Beacon Fen Energy Park – Development Consent Order

Application Reference: **EN010151**

Document: Deadline 8 – Closing Summary Statement (LCJM)

Author: Matthew Mountain, Director, L.C.J. Mountain Farms Ltd

PART OF  SLR

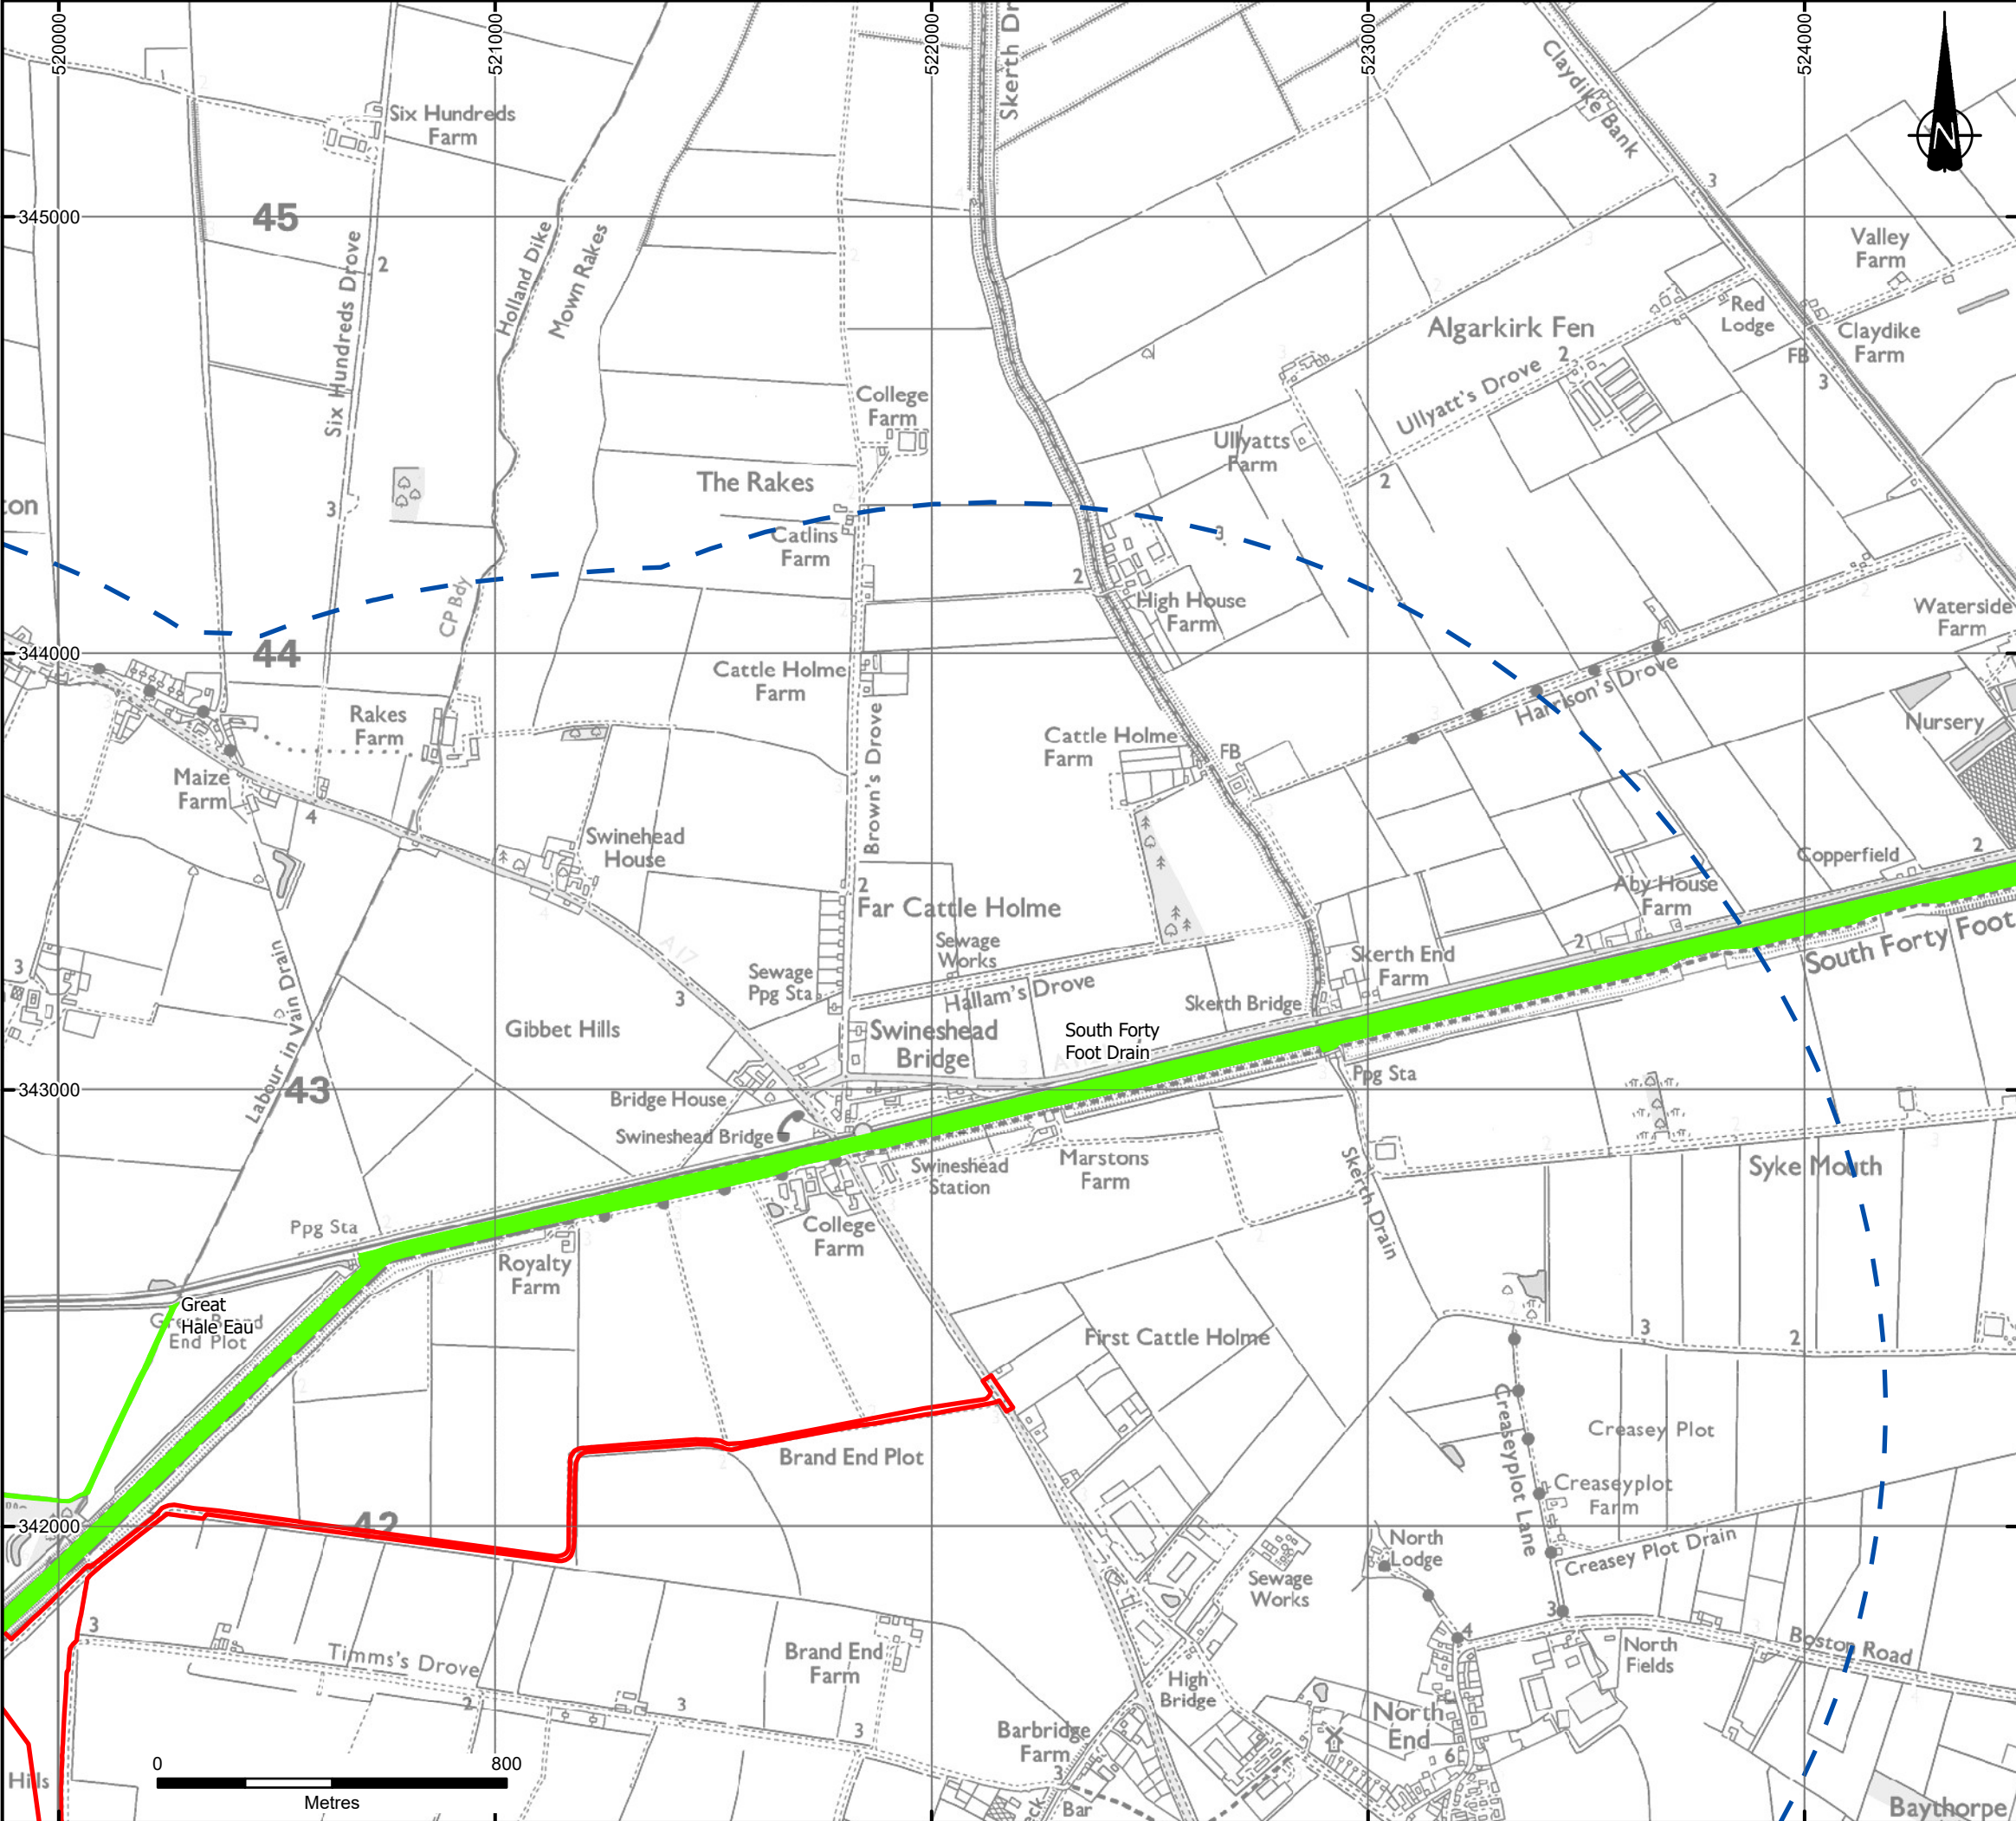
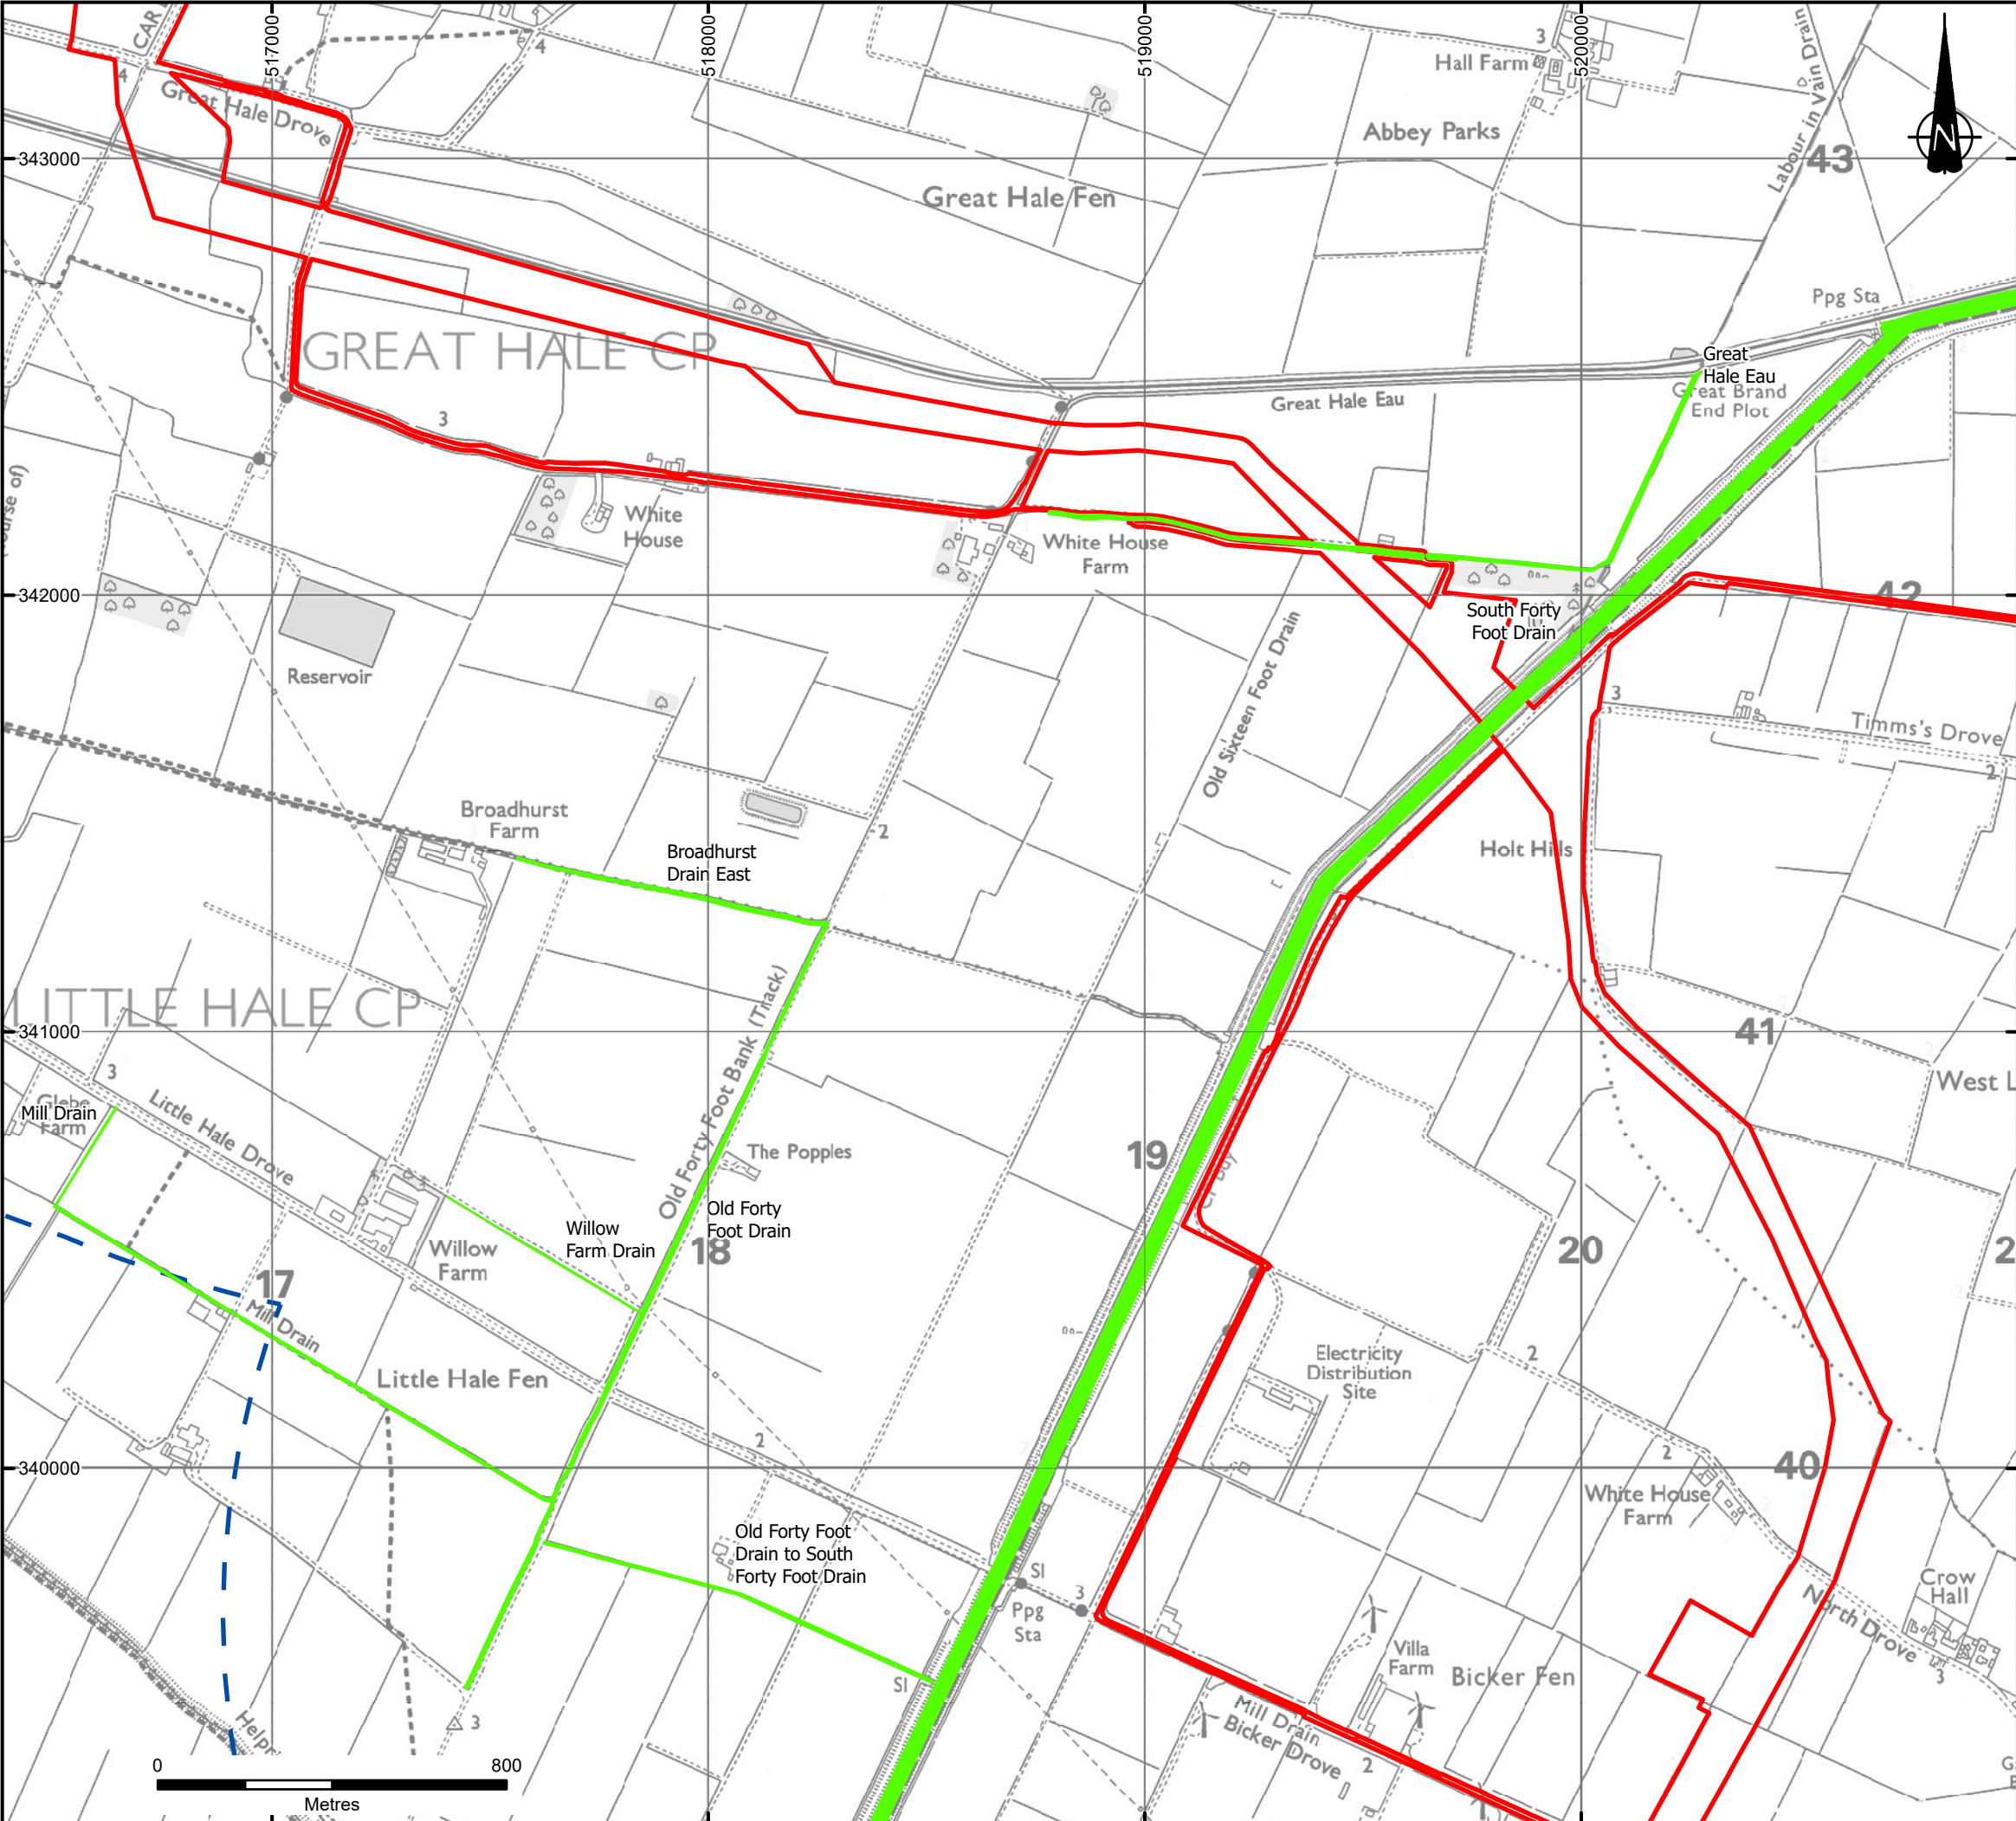
LCJM's case is that the Applicant treats LWS proximity/interaction as a discriminator against "alternatives" yet accepts substantial longitudinal interaction [1,650 metres] and "double occupation" adjacent to LWS 4722 on the chosen corridor, while simultaneously presenting temporary access as benign.

5.4a LCJM also records the decisive point for weight: the LCJM Hybrid alignment **avoids 1,650 metres occupation of LWS 4722 entirely** (i.e. it does not intersect that LWS and does not require longitudinal working alongside it). This matters because the Applicant’s own optioneering narrative treats proximity to “sensitive receptors including Local Wildlife Sites” as a discriminator against alternatives, yet the chosen corridor accepts prolonged, longitudinal interaction and indicative “double occupation” adjacent to LWS 4722. LCJM invites the ExA to record that this is not a decision-safe use of a constraint: **LWS sensitivity cannot be relied upon to rule out alternatives while being treated as acceptable-by-assumption on the selected corridor.** On that basis, LCJM invites the ExA to place reduced weight on the Applicant’s LWS-based comparative conclusions unless and until the Applicant provides an auditable, like-for-like construction footprint (including haul/access) and enforceable controls that prevent corridor creep and longitudinal working effects.

5.5 LCJM also records that the LCJM Hybrid alignment on the Little Hale Drove section has meaningful stand-off from nearby LWS features and does not intersect those LWS designations. LCJM has previously recorded on the Examination record that LWS 4489 (Mill Drain) lies approximately 274m south of the relevant section and LWS 4520 (Willow Farm Drain) lies approximately 177m north. LCJM maintains that it is not decision-safe to discount an alternative on the basis of LWS proximity while, for the chosen corridor, treating substantial longitudinal working / “double occupation” adjacent to an LWS receptor (LWS 4722) as acceptable by assumption. LCJM further notes the cumulative construction context at this location arising from the relatively recent Viking Link onshore works, which reinforces why LWS-related comparisons should be based on mapped, like-for-like construction footprints and duration assumptions rather than corridor-only screening.
